DELEGATED HOUSEHOLDER DECISION

Item No. Report of the Head of Planning, Sport and Green Spaces**Address** 35 PARK AVENUE RUISLIP**Development:** Single storey side extension**LBH Ref Nos:** **5028/APP/2015/3294****Drawing Nos:** Location Plan (1:1250)
BD/15/22/1
BD/15/22/2**Date Plans Received:** 01/09/2015**Date(s) of Amendment(s):****Date Application Valid:** 01/09/2015**1. CONSIDERATIONS****1.1 Site and Locality**

Drawing No: **BD/15/22/1**

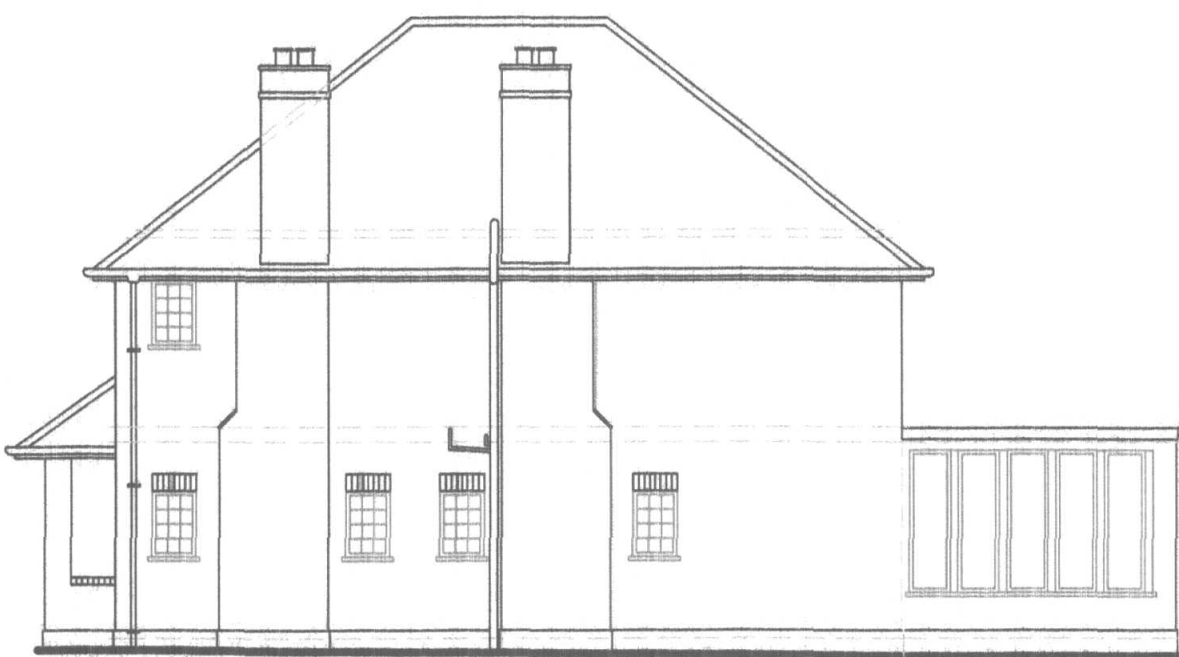
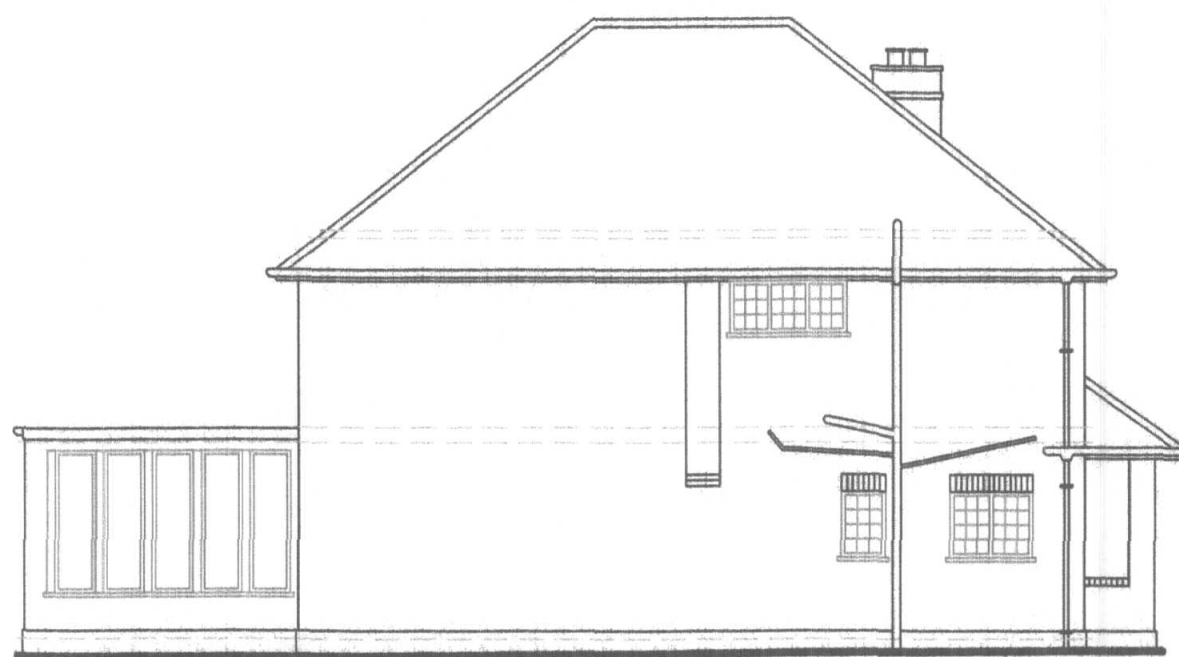
One response was received from a neighbour who advised the rear extension as approved is not as built with it extending substantially further into the garden and is higher. This application is for a side extension based on the originally submitted planning application, showing a significantly smaller rear extension and does not reflect the current structure of the property.

Officer Response: for the purpose of the assessment of this application the plans showing the rear extension as approved have been accepted. However it is noted that the plans show 5 window panels along the side elevation, which when viewed during the site visit has increased to 7 and the thickness of the combined soffit and eaves appears significantly greater in the site photos than are shown on the submitted plans, suggesting the rear extension has not been built in accordance with the approved plans. This would be a separate issue to be taken up by the Enforcement team.
